# **Comments appertaining to ESSO's response to RBC's written representations 1 (Deadline 2)**

**Application by ESSO Petroleum Company Ltd  
for an Order Granting Development  
Consent for the Southampton to London  
Pipeline Project**

**Application Reference EN070005**

**Internal Reference 19/00432/PINS**

**Drawing title**  
 QUEEN ELIZABETH PARK  
 ARBORICULTURAL SURVEY

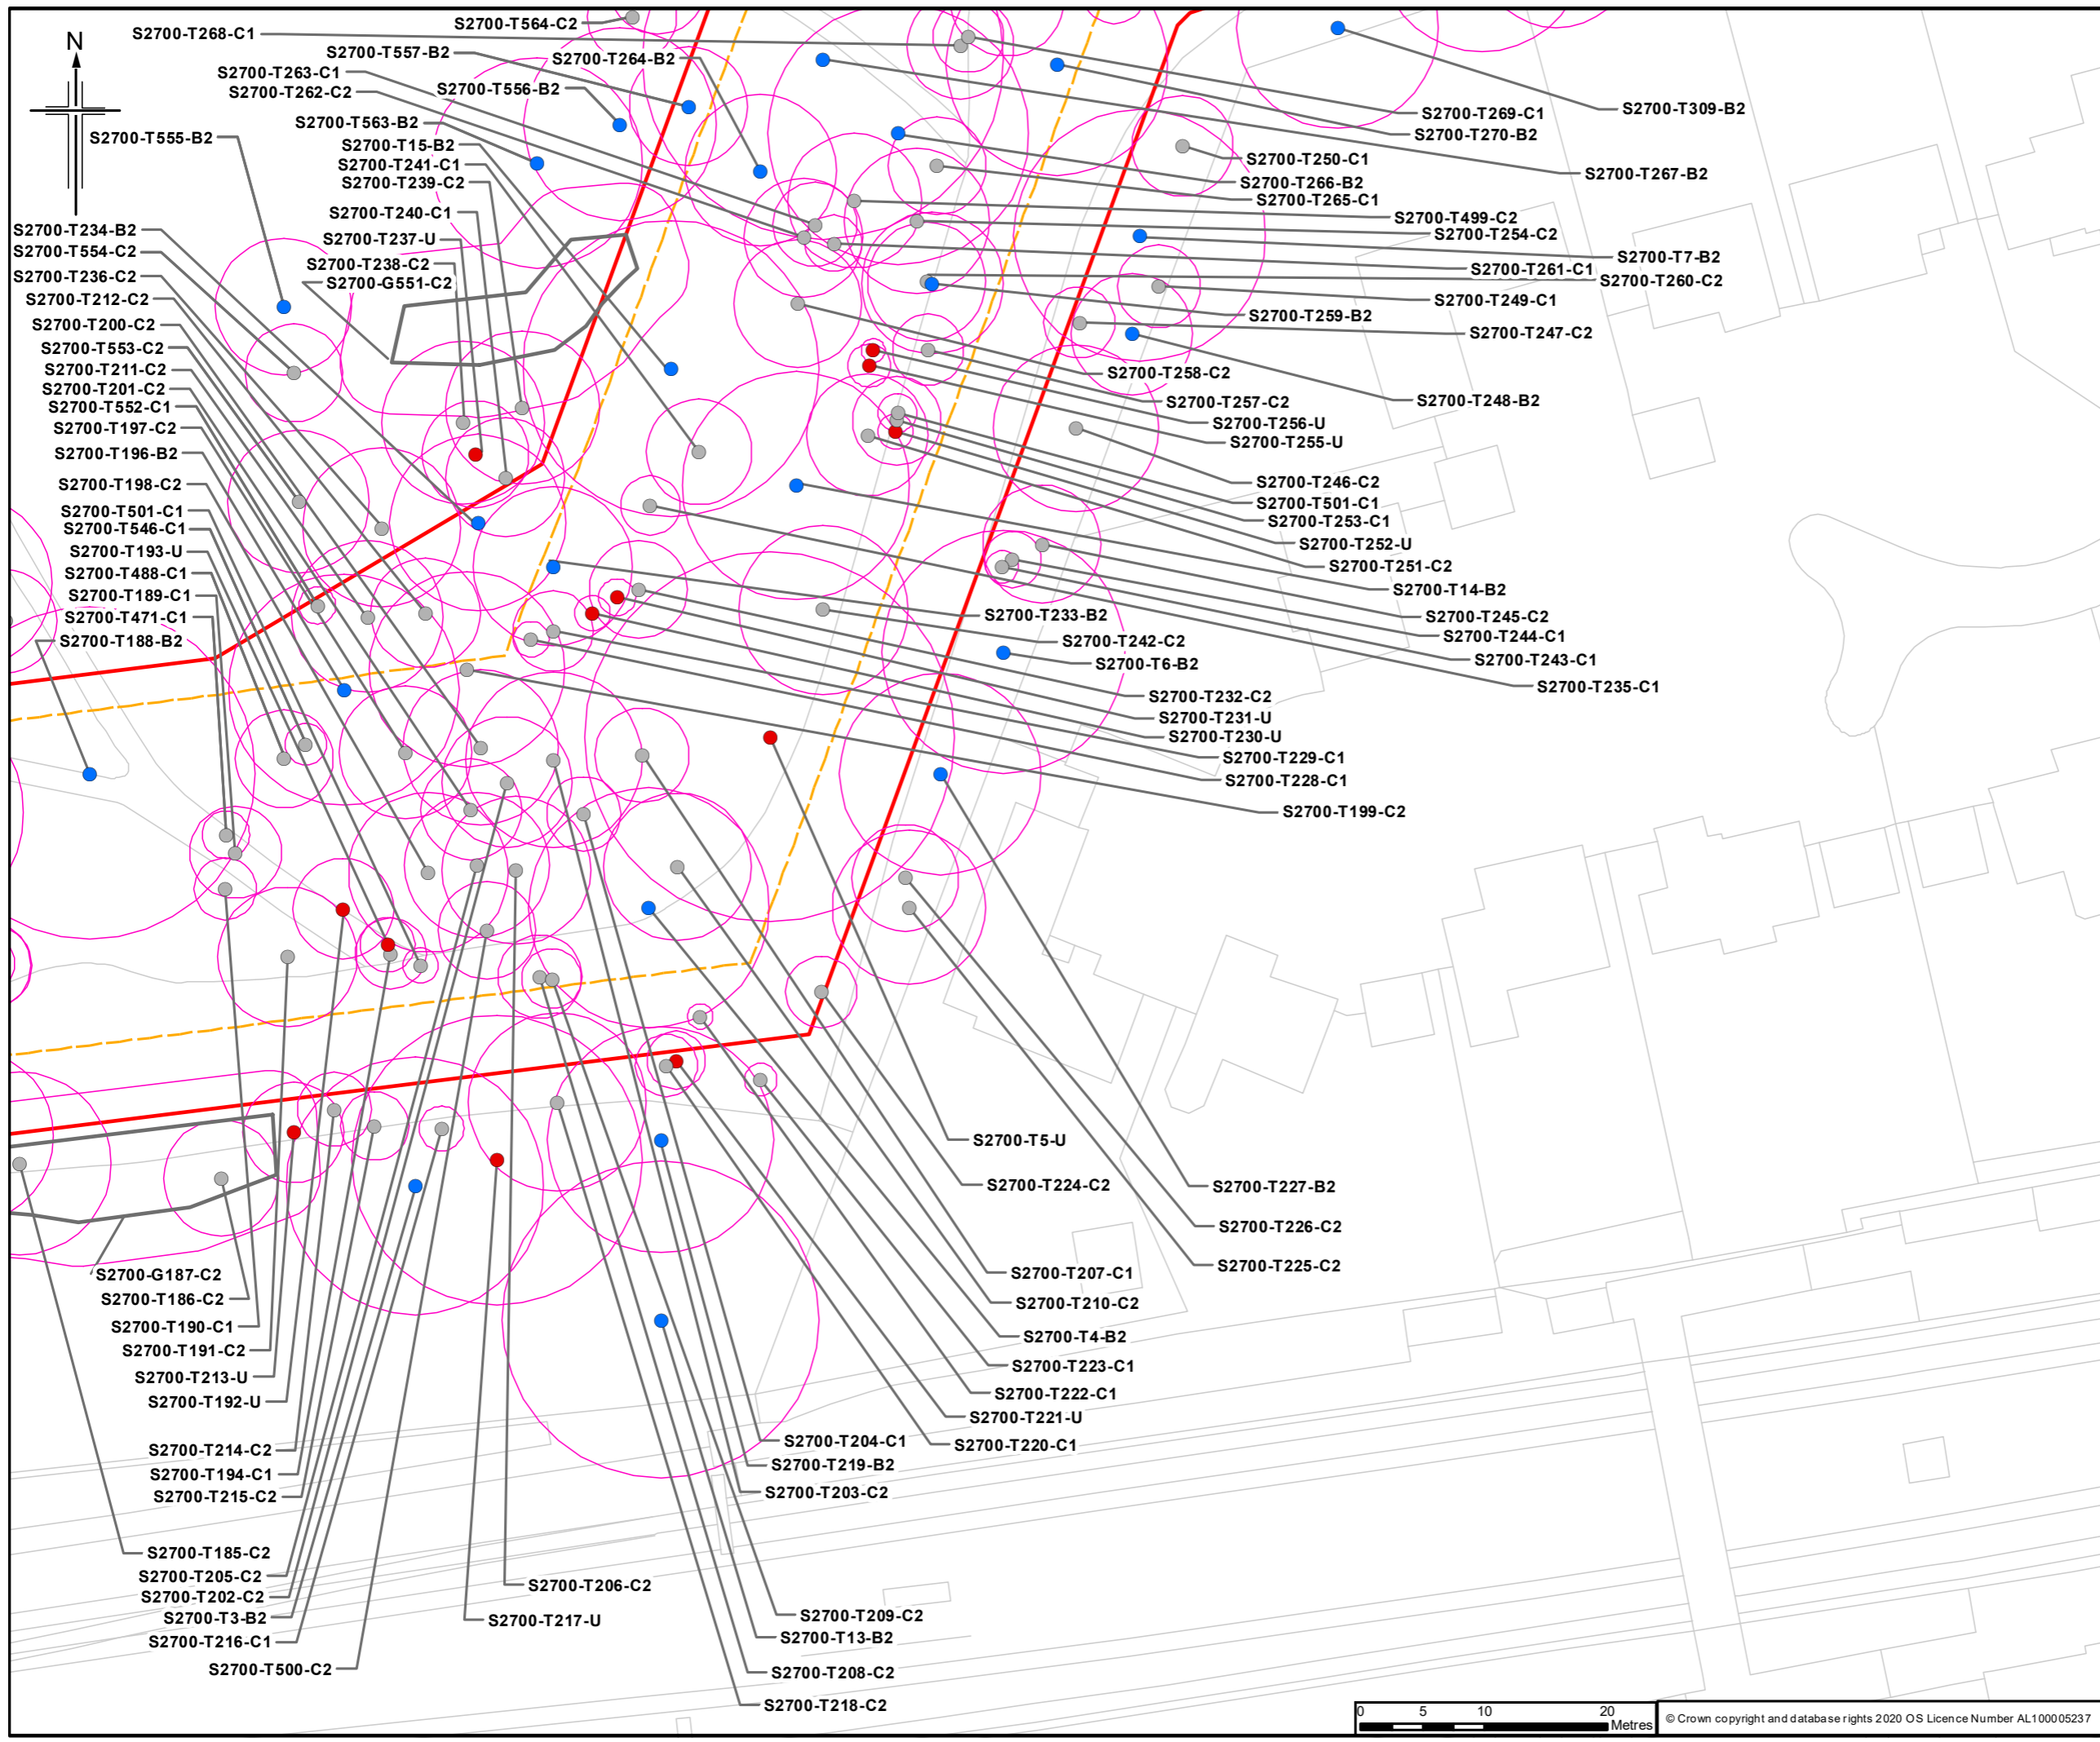
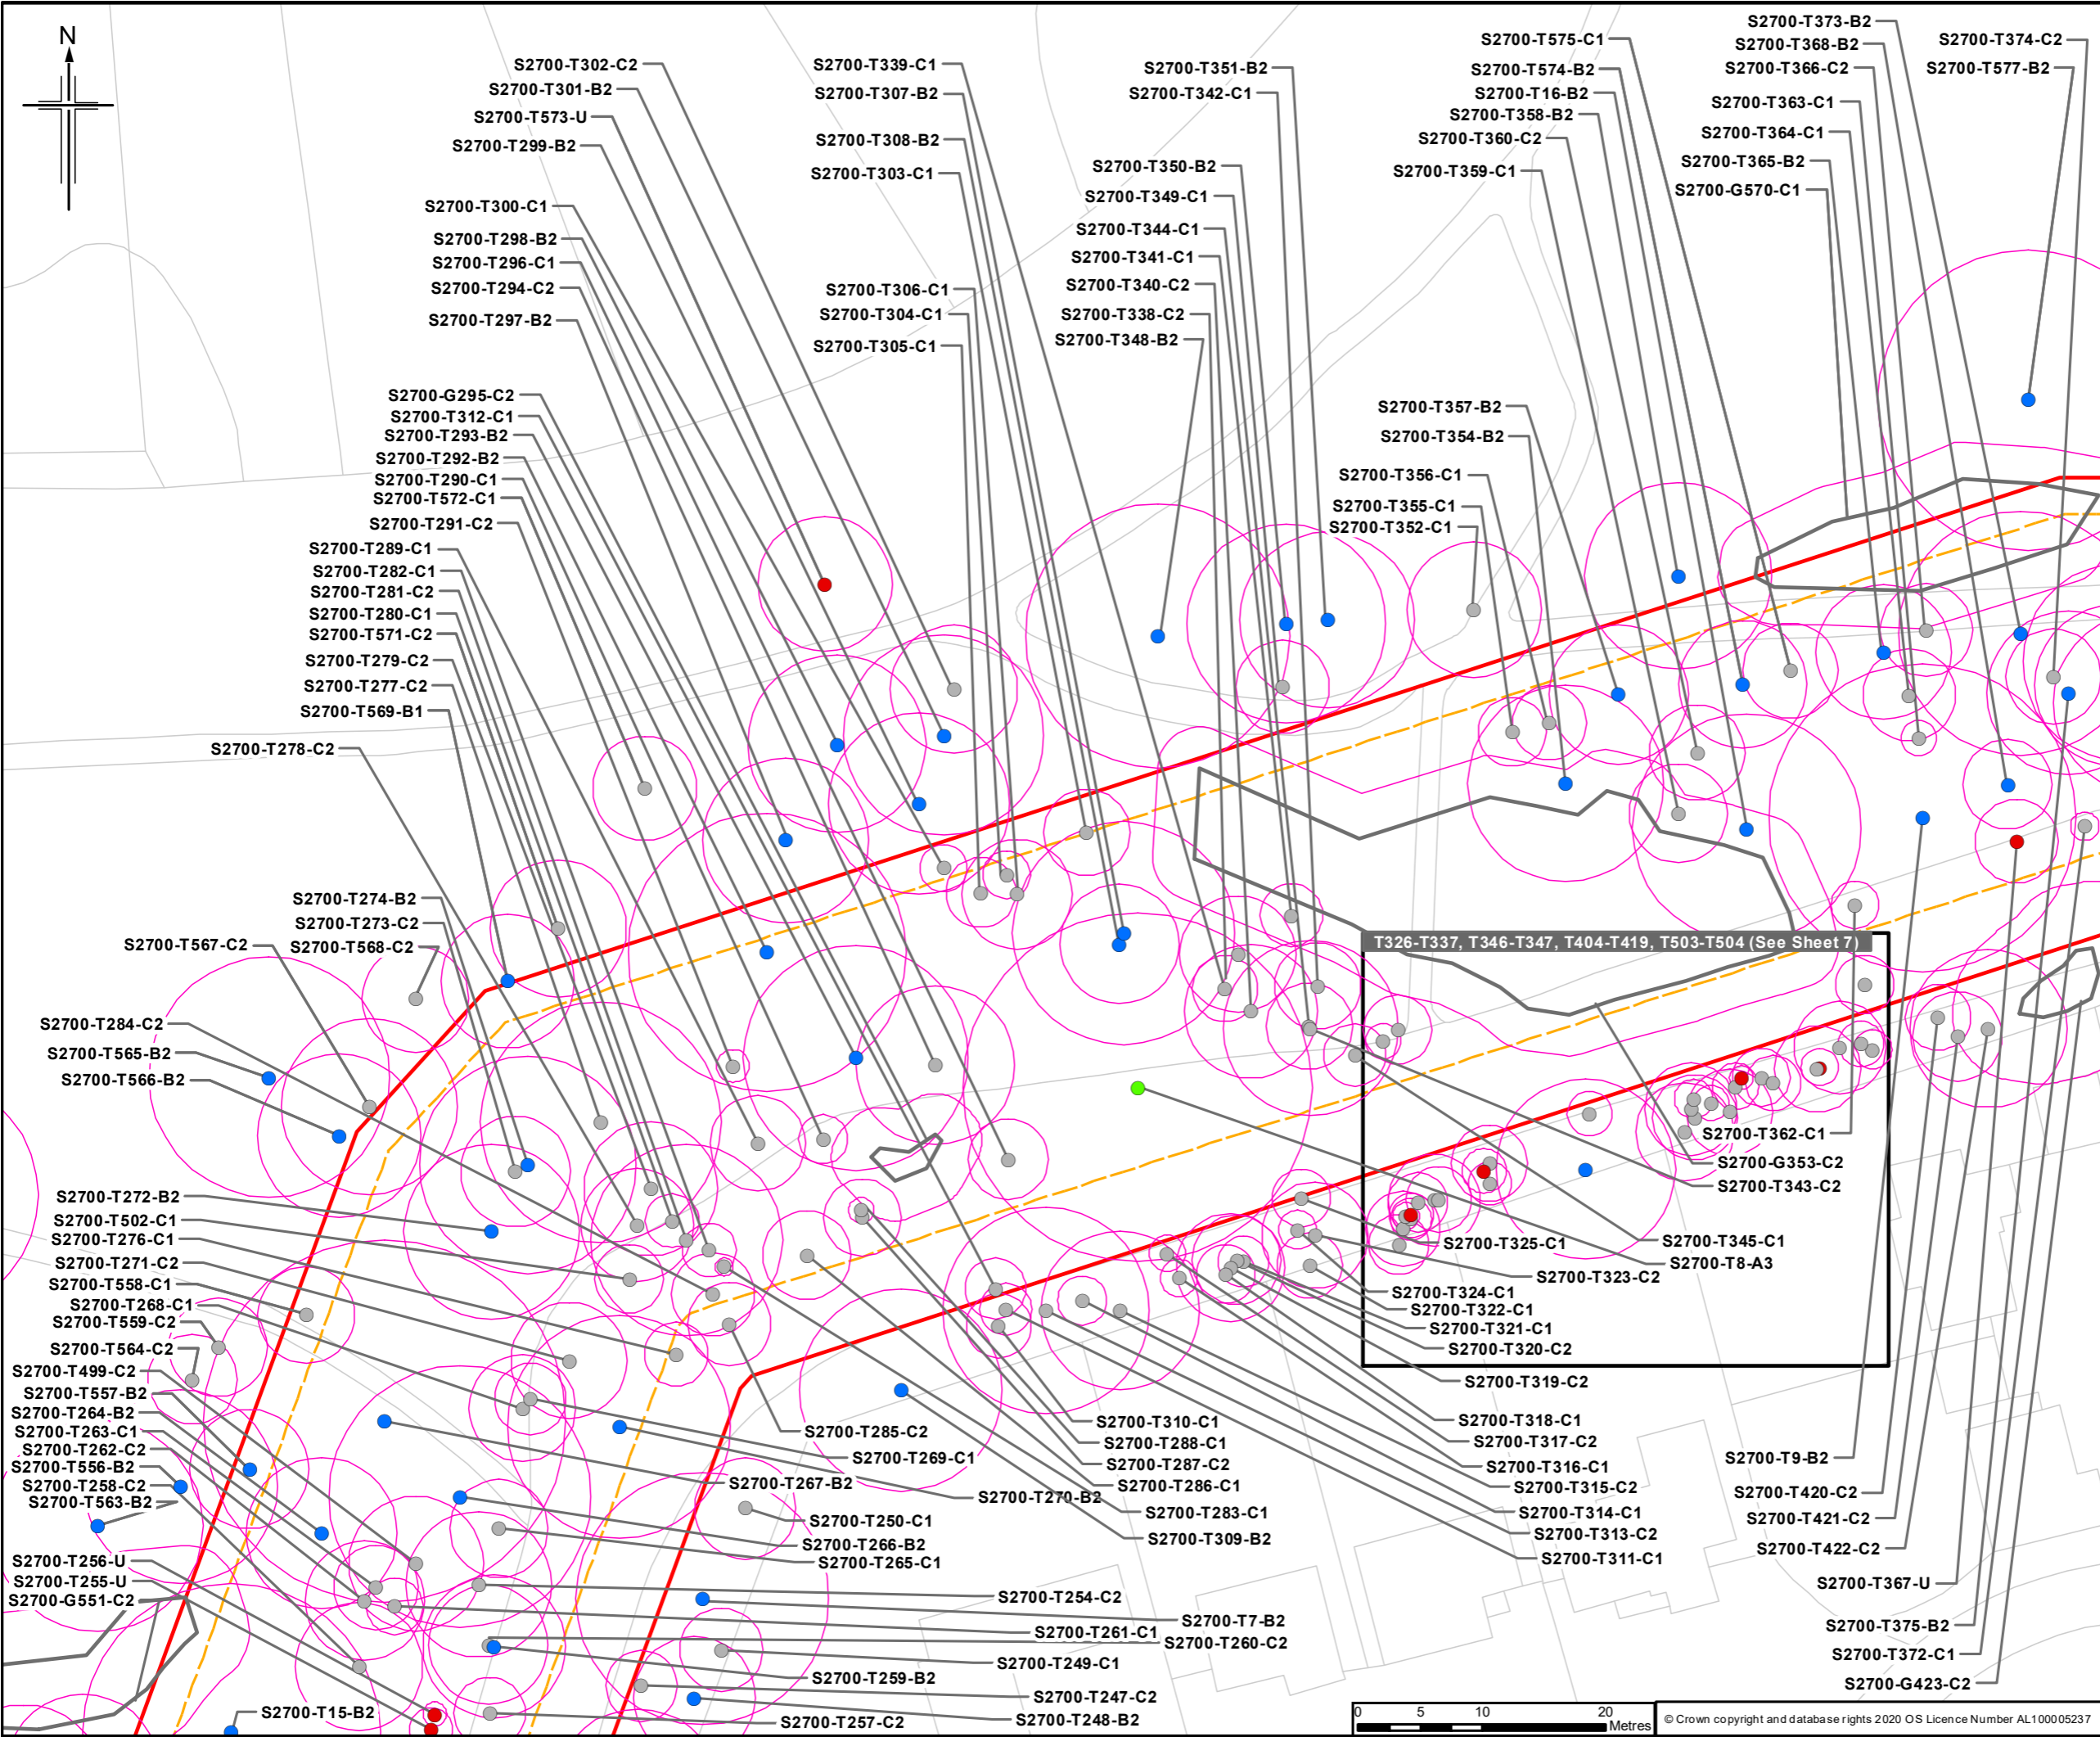
- 4.4 In respect of Queen Elizabeth Park the council would have expected this site to be surveyed due to the significant loss of the priority mixed broadleaved deciduous woodland. However the original survey missed many notable and veteran trees and therefore their loss was not

- 4.6 The council is particularly concerned regarding the assessment undertaken within Queen Elizabeth Park. Although many trees within the order limits appear to contain bat potential, with a significant number of notable and veteran trees present within the park, only two trees were climbed. The council has agreed for ESSO to undertake further bat and tree condition surveys within QEP which RBC understands are to be submitted at deadline 4. If we still feel that the information is inadequate we intend to undertake our own survey which we will submit before the next hearings, along with comments on the next steps required.
